Rosefield Solar Farm

Schedule of Changes to the draft DCO (Tracked)

EN010158/APP/~~8.1.28.1.3~~
Revision ~~23~~
Deadline ~~12~~
~~March~~ April 2026
Rosefield Energyfarm Limited

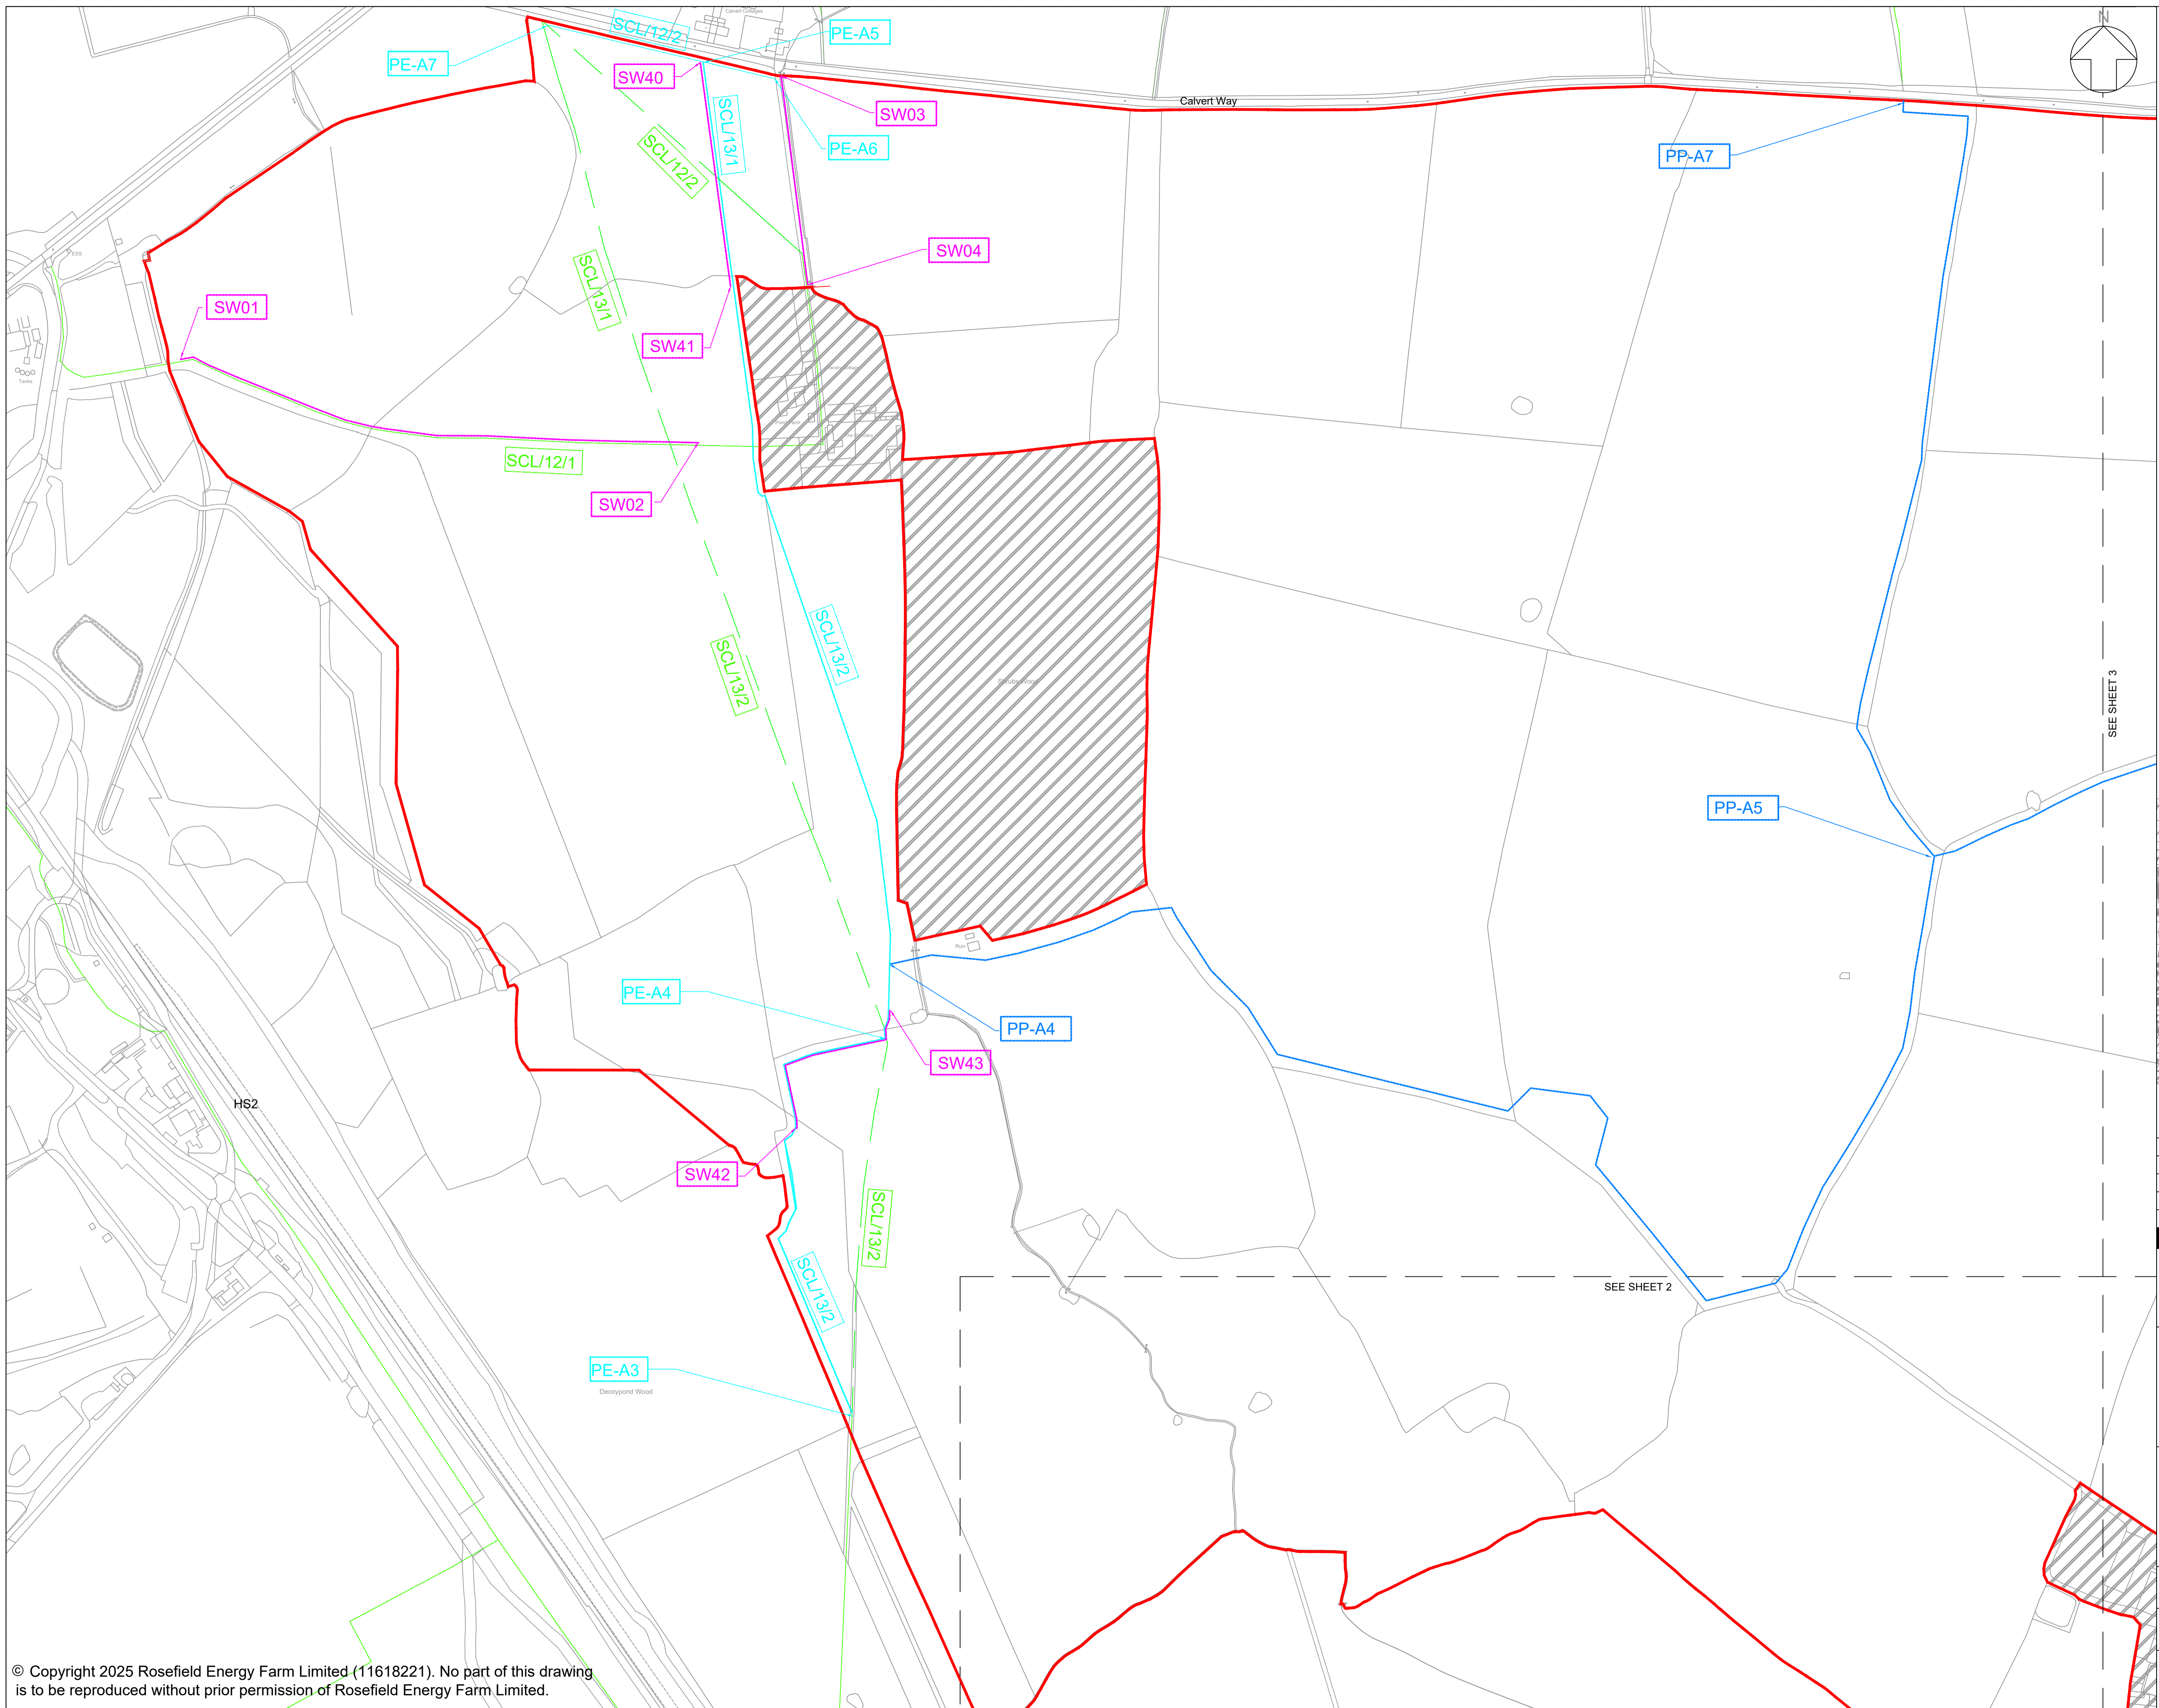
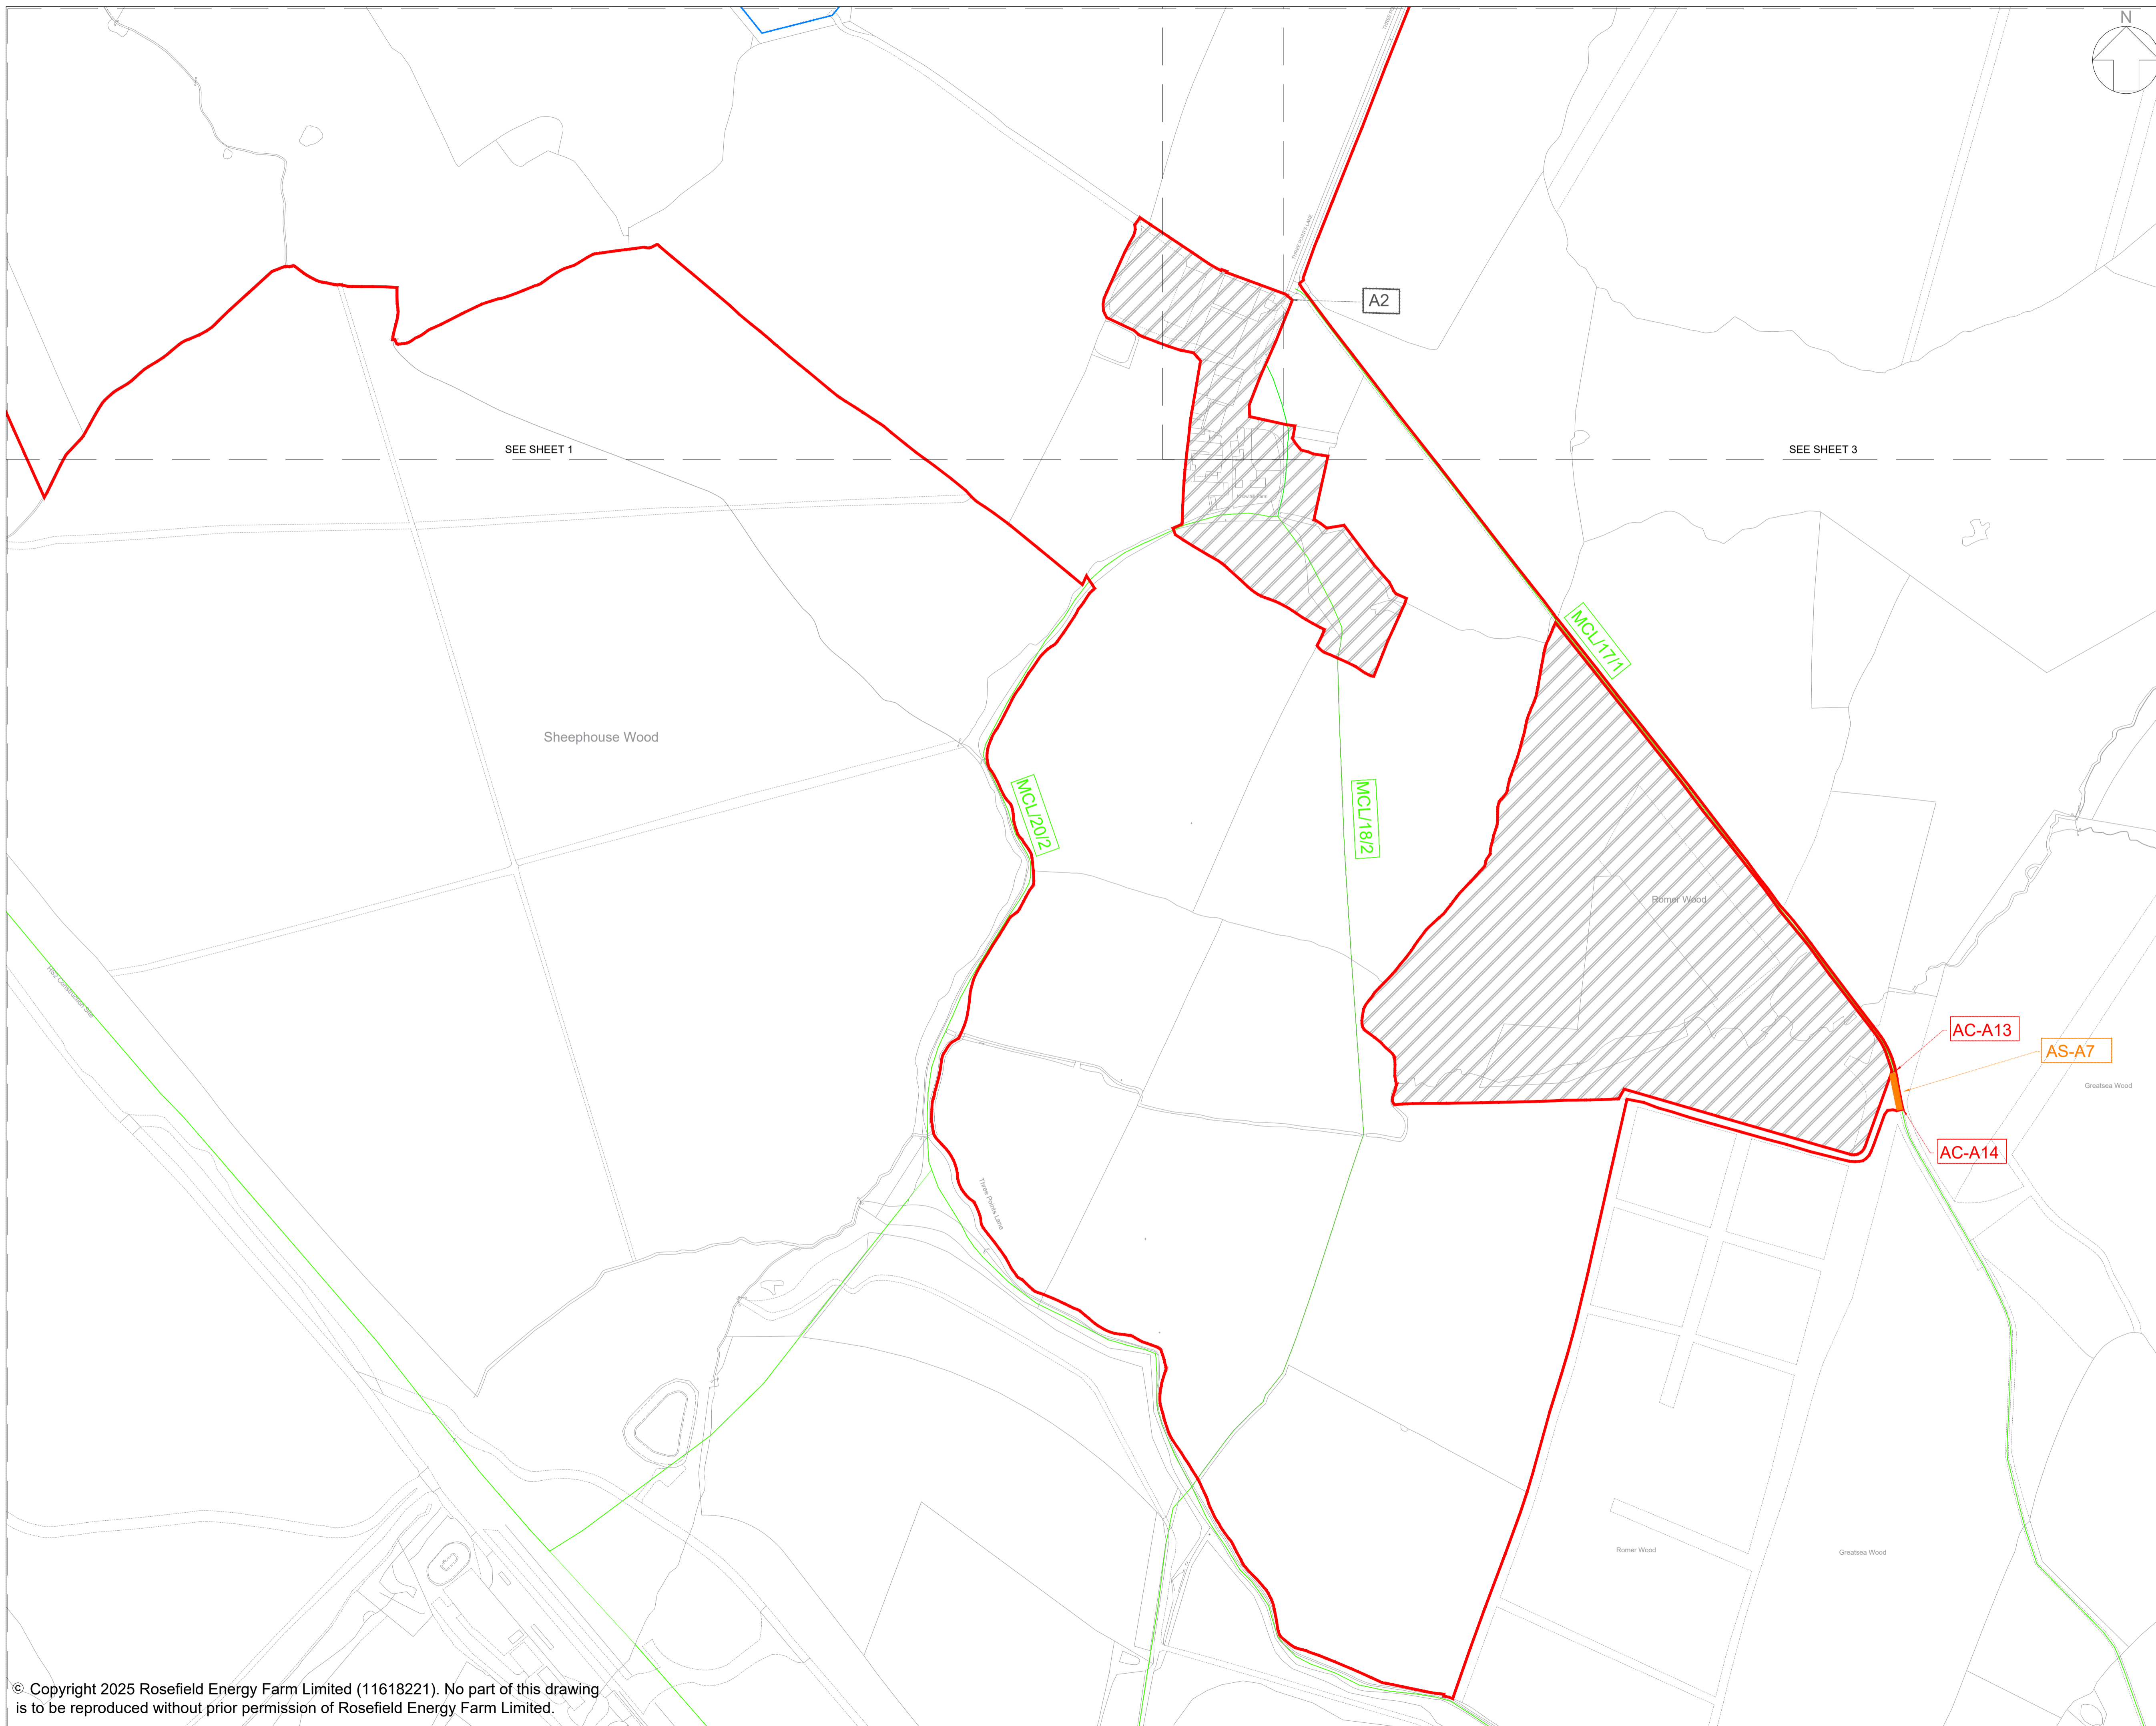
Reference	Change	Reason for Change	Deadline								
	<p>Environment Agency and Anglian Water Services Limited or its successor in function as the relevant water undertaker.</p> <p>(2) The written details under sub-paragraph (1) must be substantially in accordance with the outline drainage strategy.</p> <p>(3) Any approved strategy must be implemented as approved and maintained throughout the construction and operation of the authorised development.</p>	<p>representation [RR-081] and AWS' relevant representation [RR-012], where each requested to be a consultee.</p>									
<p>Schedule 2, Requirement 14 (Operational noise)</p>	<p>14. – (1) No part of Work Nos. 1 to 5 may commence until an operational noise assessment containing details of how the design of that numbered work has incorporated mitigation to ensure the operational noise rating levels as set out in paragraph 13.9.19 of chapter 13 of the environmental statement are complied with for that part has been submitted to and approved by the relevant planning authority.</p>	<p>Addition of reference to more specific operational noise limits on the face of dDCO.</p>	<p>1</p>								
<p>Schedule 6, Part 1 (PRoW to be permanently stopped up and diverted)</p>	<table border="1"> <thead> <tr> <th data-bbox="443 826 725 979"><i>(1) Area</i></th> <th data-bbox="725 826 1008 979"><i>(2) Public right of way to be stopped up</i></th> <th data-bbox="1008 826 1290 979"><i>(3) Extent of stopping up</i></th> <th data-bbox="1290 826 1572 979"><i>(4) New public right of way to be substituted / provided</i></th> </tr> </thead> <tbody> <tr> <td data-bbox="443 979 725 1319"> <p>District of Buckinghamshire</p> </td> <td data-bbox="725 979 1008 1319"> <p>SCL/12/2</p> </td> <td data-bbox="1008 979 1290 1319"> <p>For a distance of 320 190 metres between points PE-A7 PE-A10 and point SW04 as shown on sheet 1 of the streets, access</p> </td> <td data-bbox="1290 979 1572 1319"> <p>New public footpath to be provided between points PE-A7, PE-A5 and its intersection with SCL/12/1 as shown by a cyan line on sheet 1 of</p> </td> </tr> </tbody> </table>	<i>(1) Area</i>	<i>(2) Public right of way to be stopped up</i>	<i>(3) Extent of stopping up</i>	<i>(4) New public right of way to be substituted / provided</i>	<p>District of Buckinghamshire</p>	<p>SCL/12/2</p>	<p>For a distance of 320 190 metres between points PE-A7 PE-A10 and point SW04 as shown on sheet 1 of the streets, access</p>	<p>New public footpath to be provided between points PE-A7, PE-A5 and its intersection with SCL/12/1 as shown by a cyan line on sheet 1 of</p>	<p>Reduction in extent of stopping up to SCL/12/2 to address Buckinghamshire Council's relevant representation [RR-026] to avoid creation of a 'dead-end'.</p>	<p>1</p>
<i>(1) Area</i>	<i>(2) Public right of way to be stopped up</i>	<i>(3) Extent of stopping up</i>	<i>(4) New public right of way to be substituted / provided</i>								
<p>District of Buckinghamshire</p>	<p>SCL/12/2</p>	<p>For a distance of 320 190 metres between points PE-A7 PE-A10 and point SW04 as shown on sheet 1 of the streets, access</p>	<p>New public footpath to be provided between points PE-A7, PE-A5 and its intersection with SCL/12/1 as shown by a cyan line on sheet 1 of</p>

Reference	Change	Reason for Change	Deadline
		and rights of way plans.	the streets, rights of way and access plans.
Schedule 9 (land in which only new rights etc. may be acquired)	7/5	Access rights, Substation connection rights	Removal of Anglian Water Services Ltd (AWS) plot 7/6 from the Order Land. Upon review and following engagement with AWS, powers are no longer sought over this plot.
	7/6	Substation connection rights	
	7/7	Substation connection rights	
<u>Deadline 2 (22 April 2026)</u>			
<u>Throughout dDCO</u>	All references to the “outline landscape and ecology management plan” updated throughout the dDCO to refer to the correct name of the outline plan, being the “outline landscape and ecological management plan”.	<u>Response to Examining Authority’s Written Questions 1 (ExQ1) [PD-010] Q1.12.8.</u>	<u>2</u>
<u>Article 2 (Interpretation)</u>	<p>“existing or approved developments” means the following developments which are within the Order limits—</p> <p>(a) <u>East Claydon BESS (reference 23/03875/APP) approved 11 September 2025; and</u></p> <p>(b) <u>East Claydon Greener Grid Park (reference 25/01297/APP) pending decision;</u></p>	<u>Response to ExQ1 [PD-010] Q1.12.13.</u>	<u>2</u>
